# CITY OF ALBUQUERQUE

January 25, 2012

**Re: Plaza at San Mateo, Tract A Vidas Subdivision  
2403 San Mateo, Grading and Drainage Plan  
Engineer's Stamp Date 12/28/2011 (H17/D103)**

**GRADING PLAN**  
C201

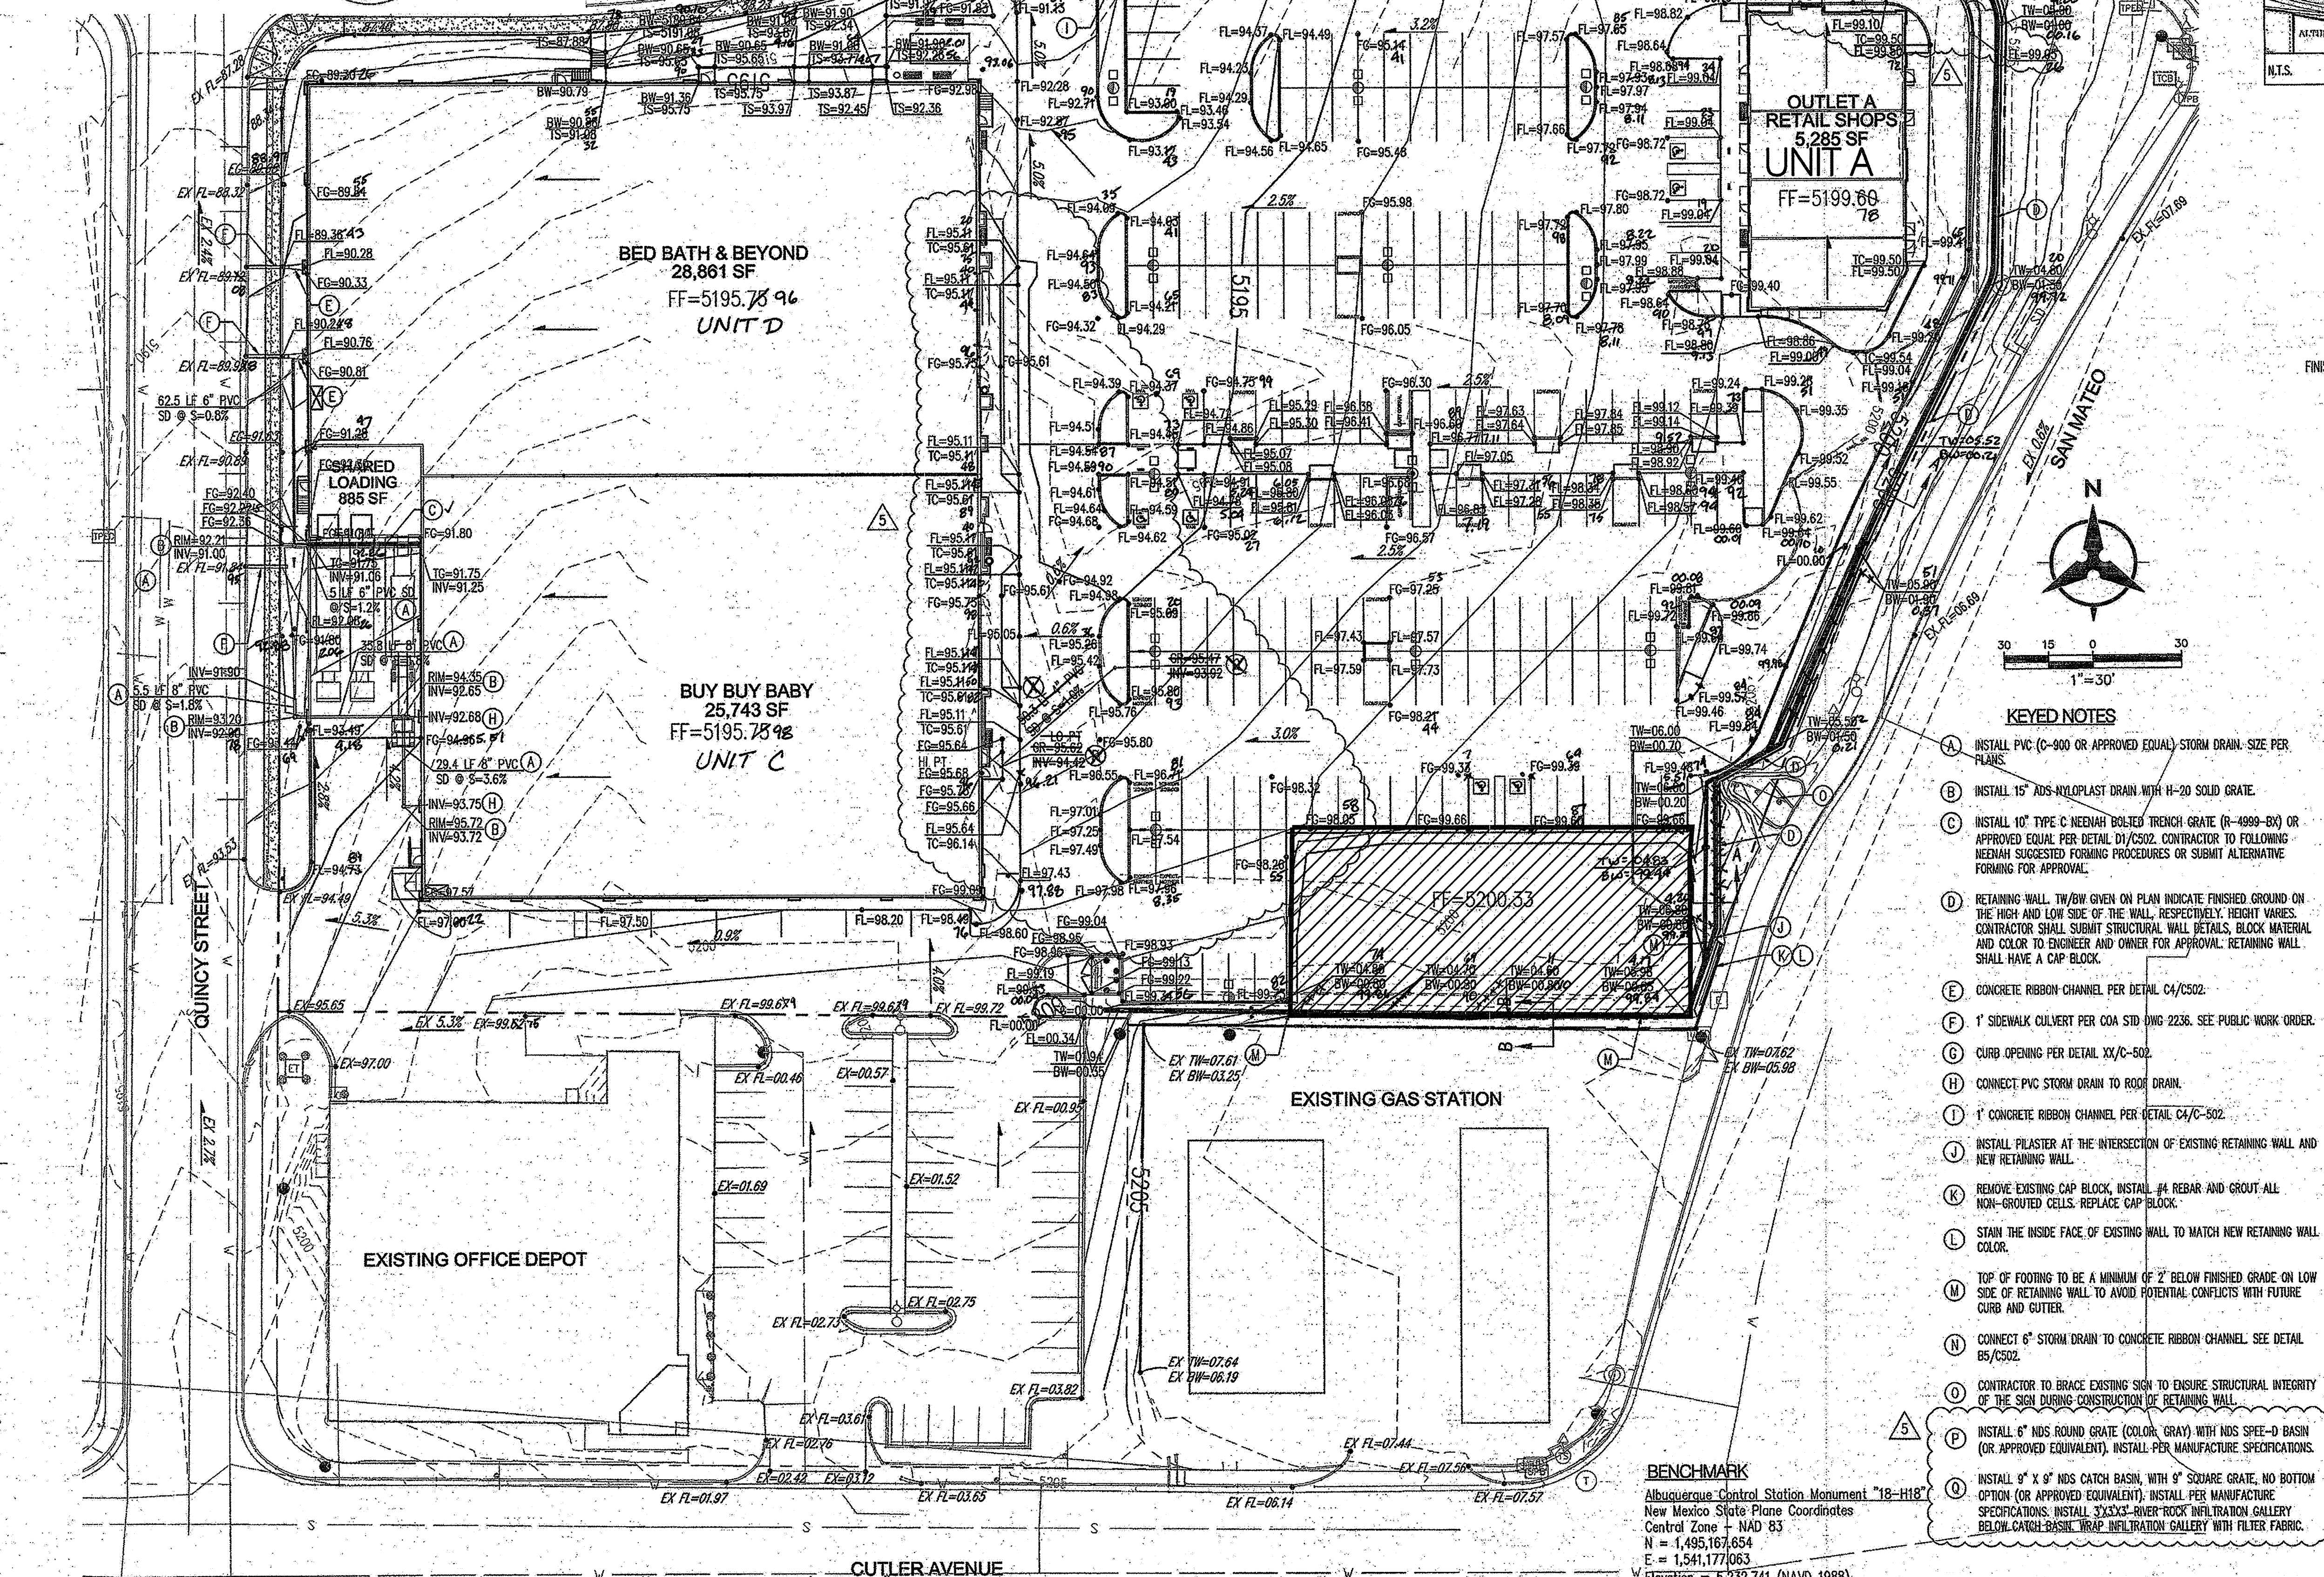
- Provide City Benchmark.
- Add a Vicinity Map to the plan.
- Show existing topography.
- Does the site fall within a 100-year floodplain? If so, include a copy of the FIRM map on the plan.
- Show roof flow directions.
- Show full finished floor elevations for the proposed buildings. Provide more proposed grades throughout the site for proper slopes and positive drainage.
- Use sidewalk culverts and depressed landscaping areas to avoid draining the runoff over the sidewalks.
- Clearly show the limits of the proposed retaining walls. A fence is shown instead of a retaining wall.
- Include Legends.
- Provide a detail for the concrete rundown.

- Hydrology is requesting that proposed landscape areas be depressed for water harvesting.
- Does any offsite runoff enter the site? Where does the existing Service Station (located at the northwest corner of the San Mateo Boulevard and Cutler Avenue) drain to?
